Case Officer: Emma Whitley

Applicant: Planned Approach Architects

Proposal: Variation of Condition 2 of 20/02859/F - to change the roof pitch from 12 to 15 degrees

ELEVATIONS, As Proposed and As Existing
 1:200 TPH October 2020
 Original at A1 Drwg no. 20 / 182.02 Rev A

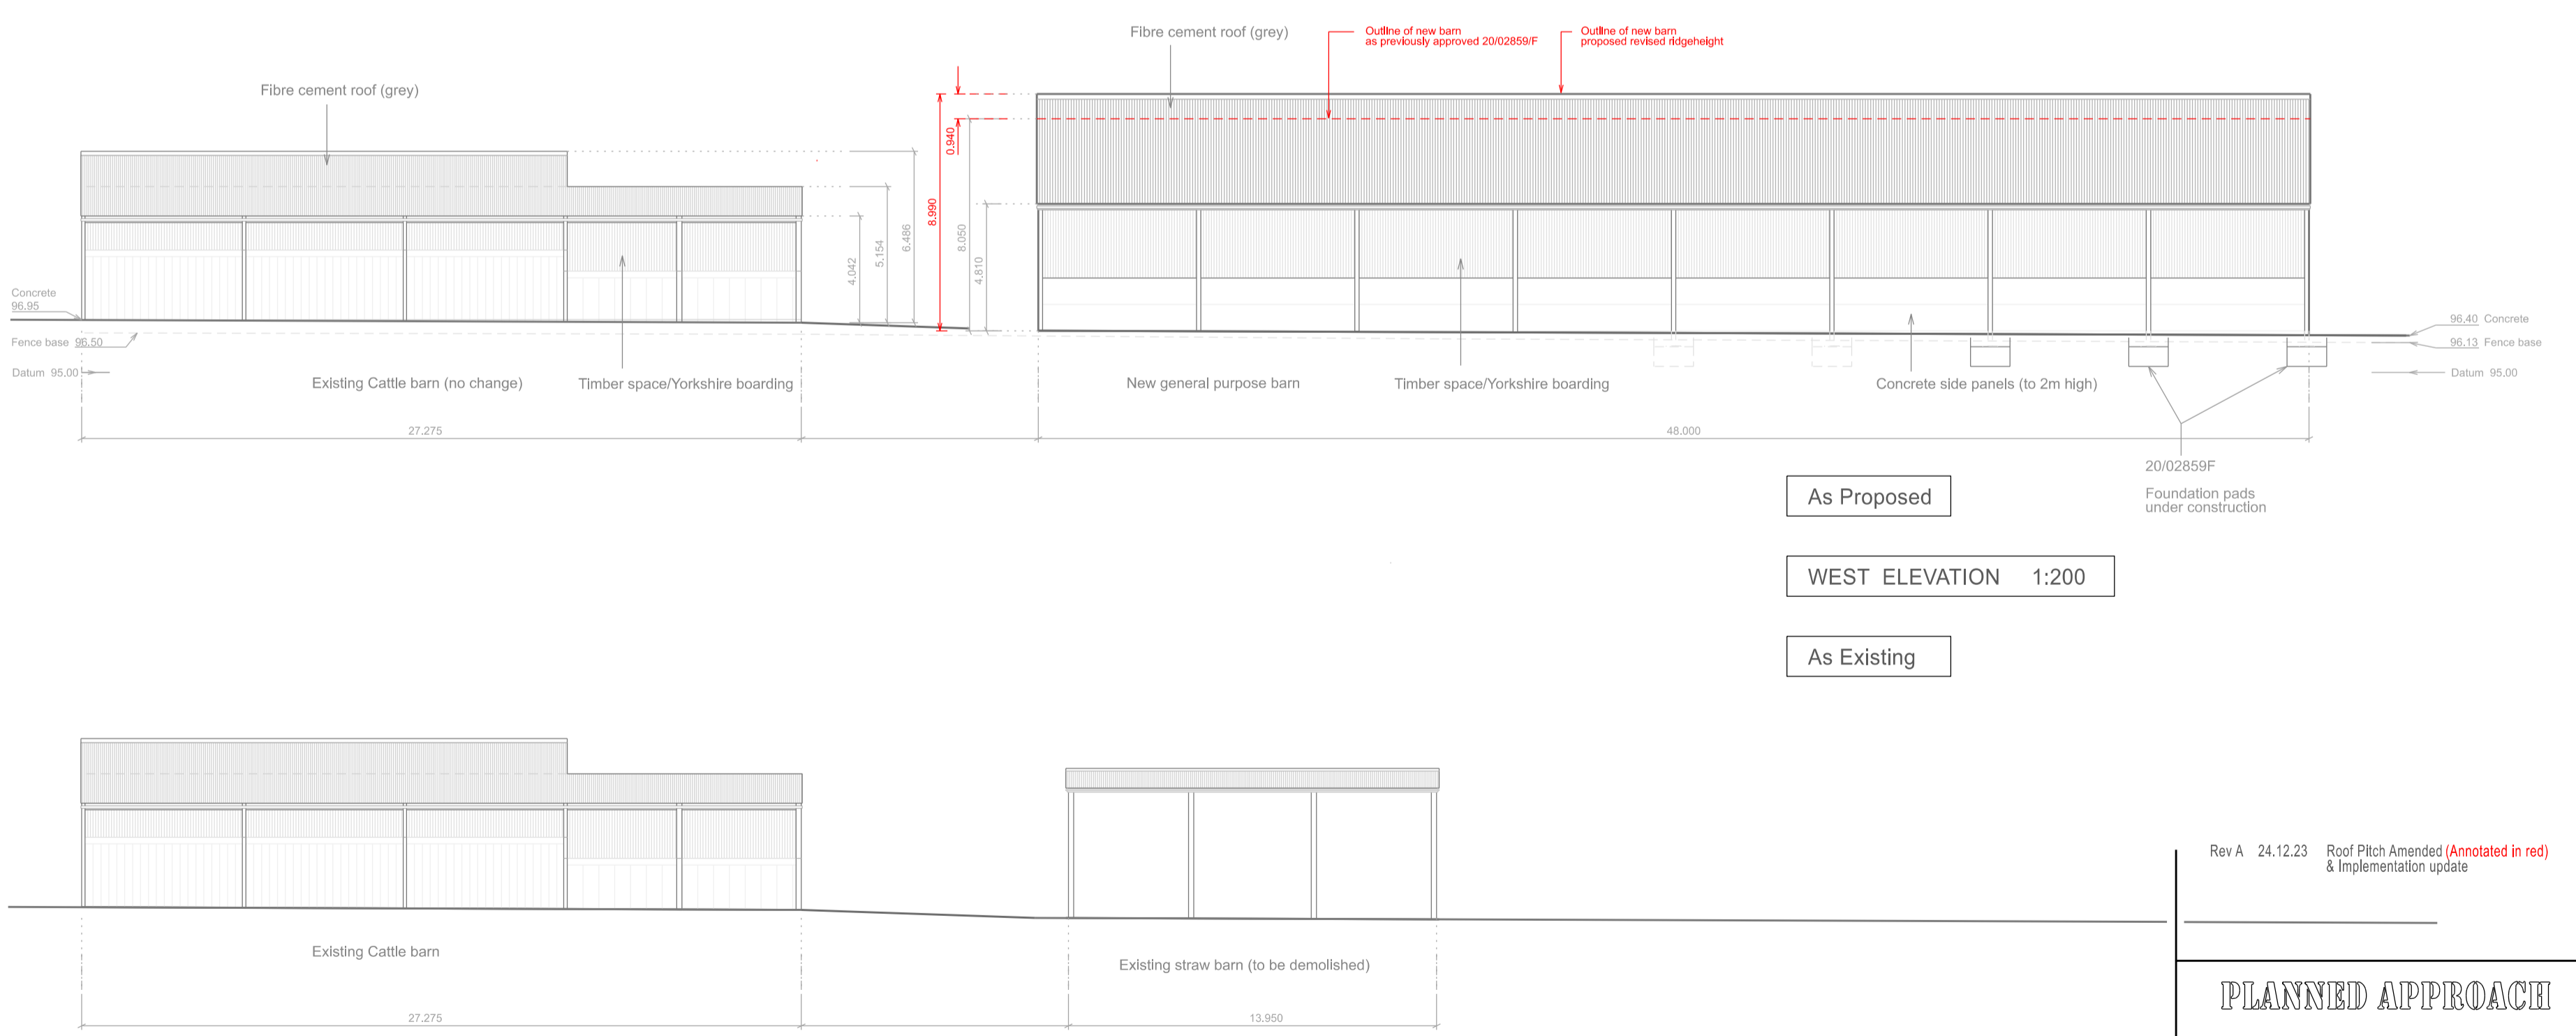
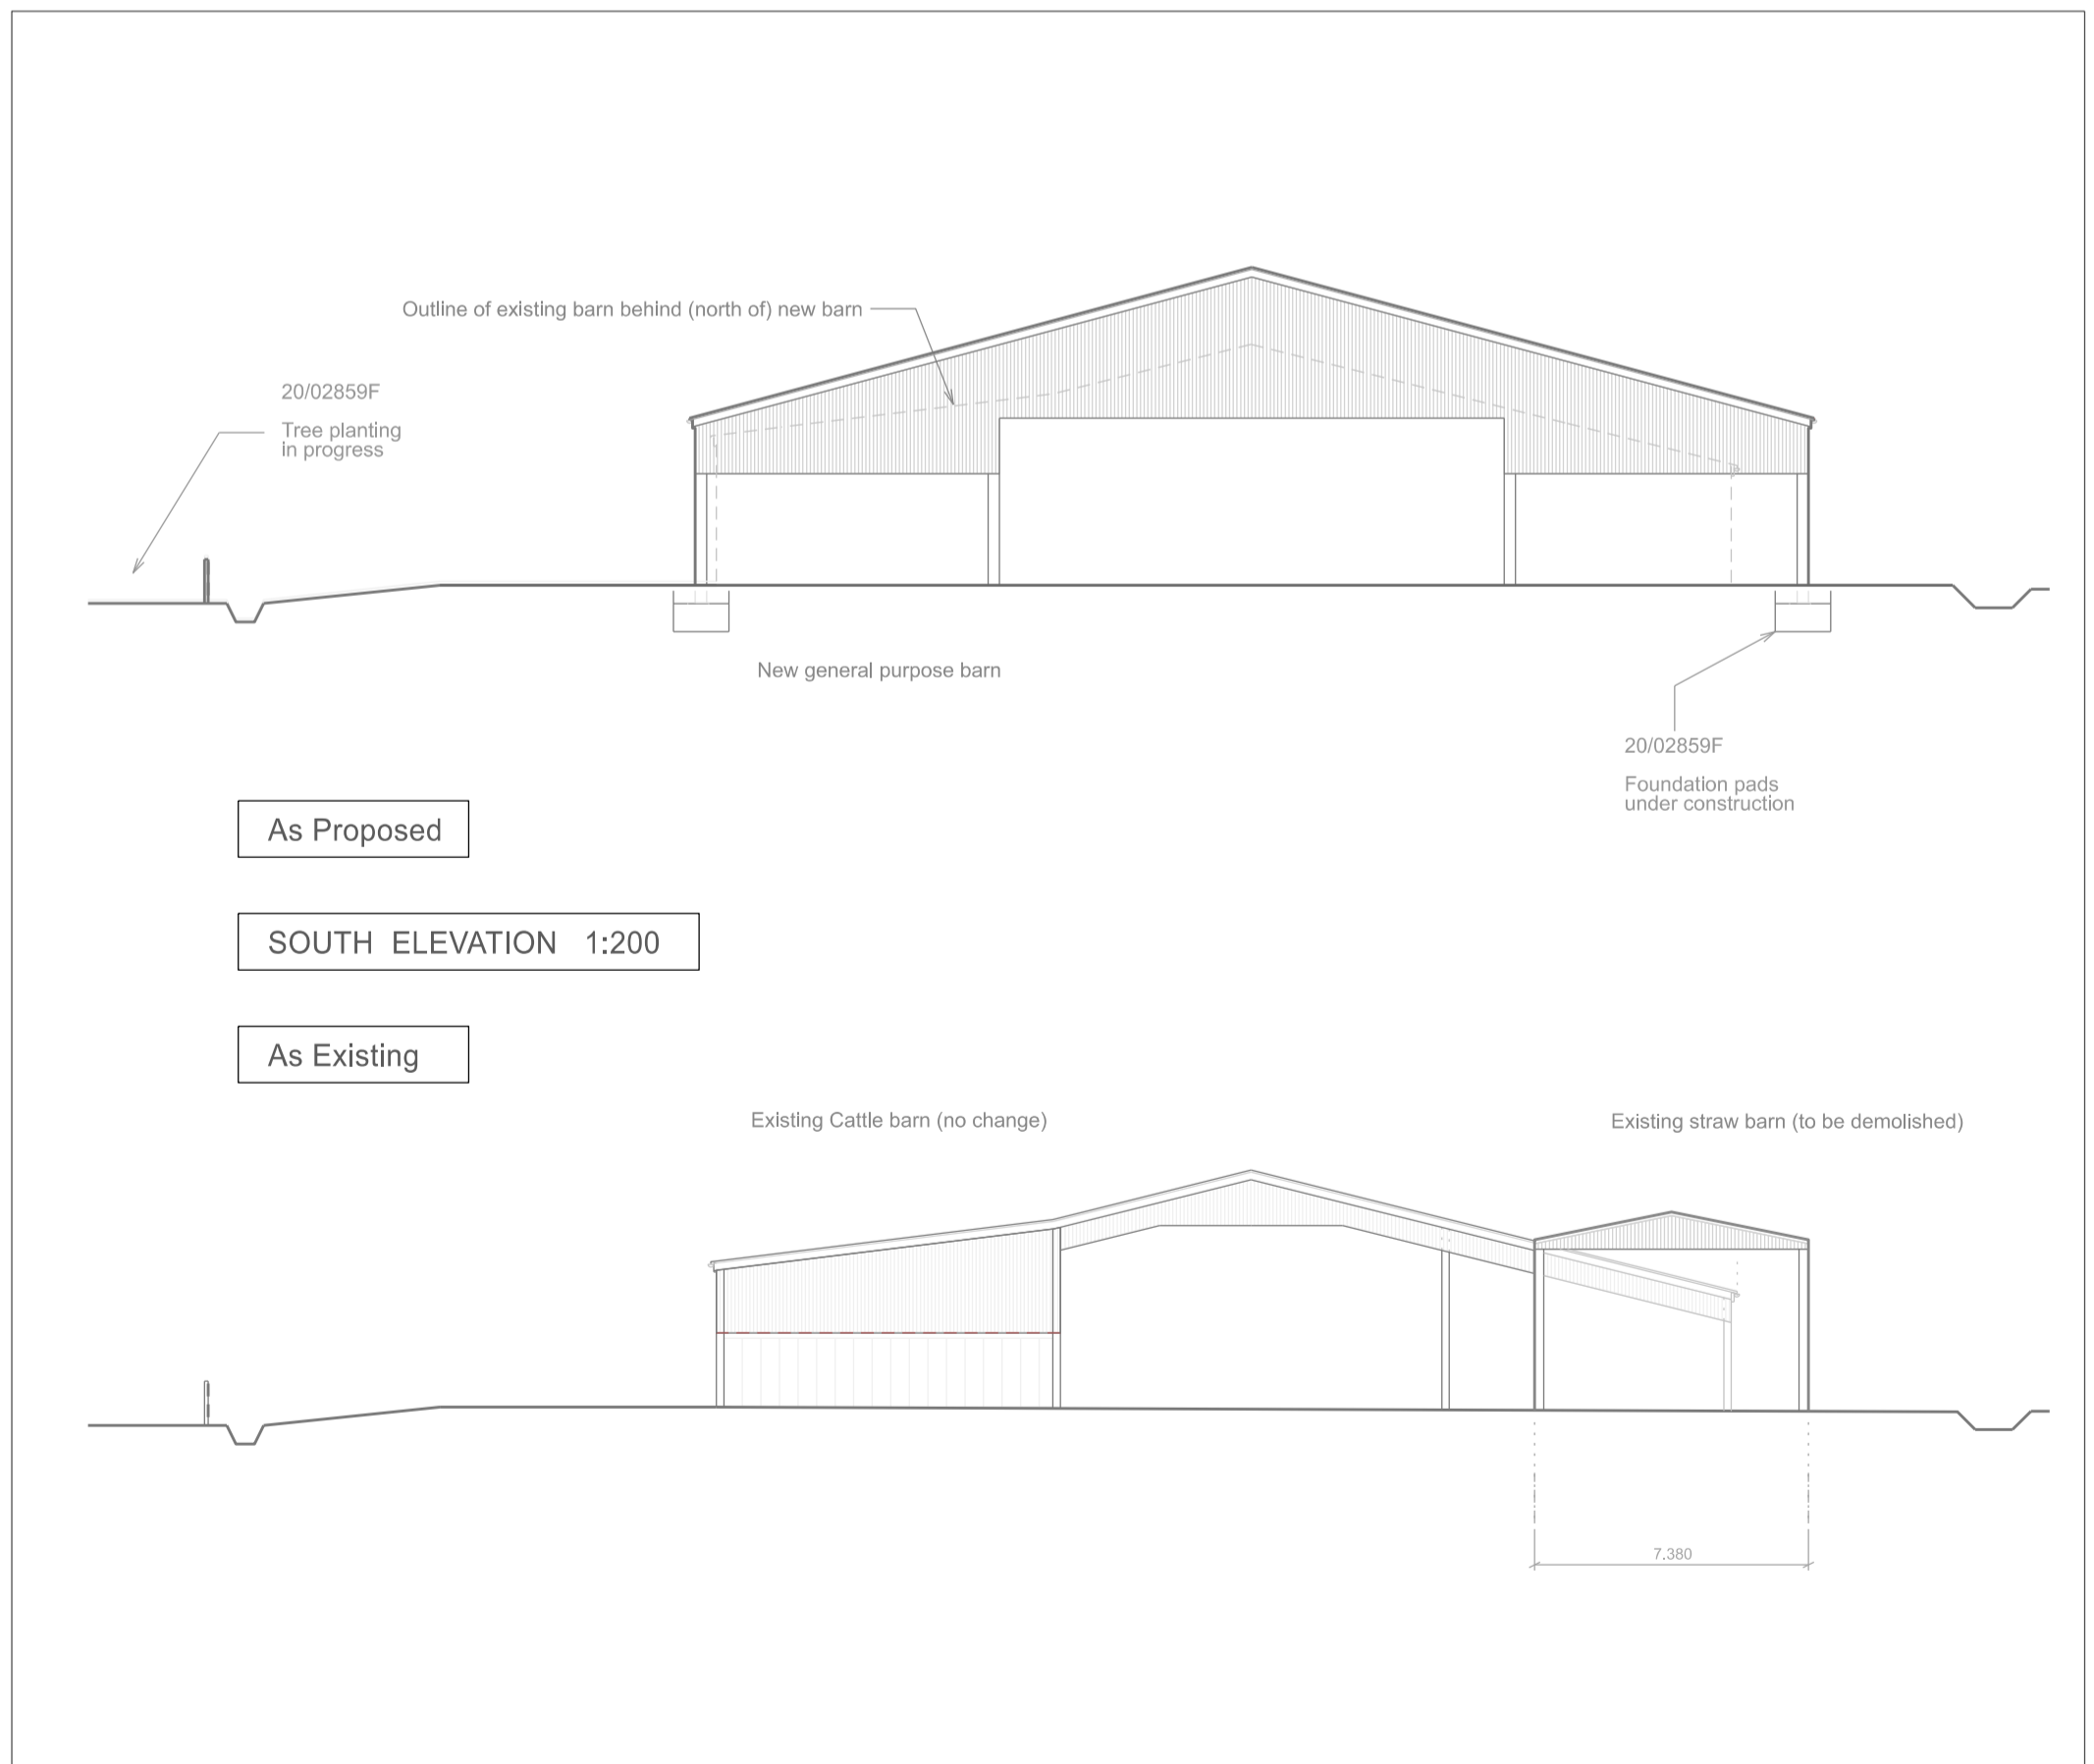
- 2.1. Planning permission is sought to vary condition 2 of permission 20/02859/F to alter the roof pitch of the building from 12 to 15 degrees, resulting in an increased roof height from 8.05m to 8.99m.
- 2.2. The change in pitch is required to make more efficient use of steel in the construction of the barn and in order to accommodate contractor's machinery to tip trailers inside the building.

- 8.7. The amendment to the roof pitch is not considered to result in any additional harm to the visual amenities than previously assessed.
- 8.8. Given the assessment above, it is concluded that the proposal accords with the above Policies in respect of its visual impact.
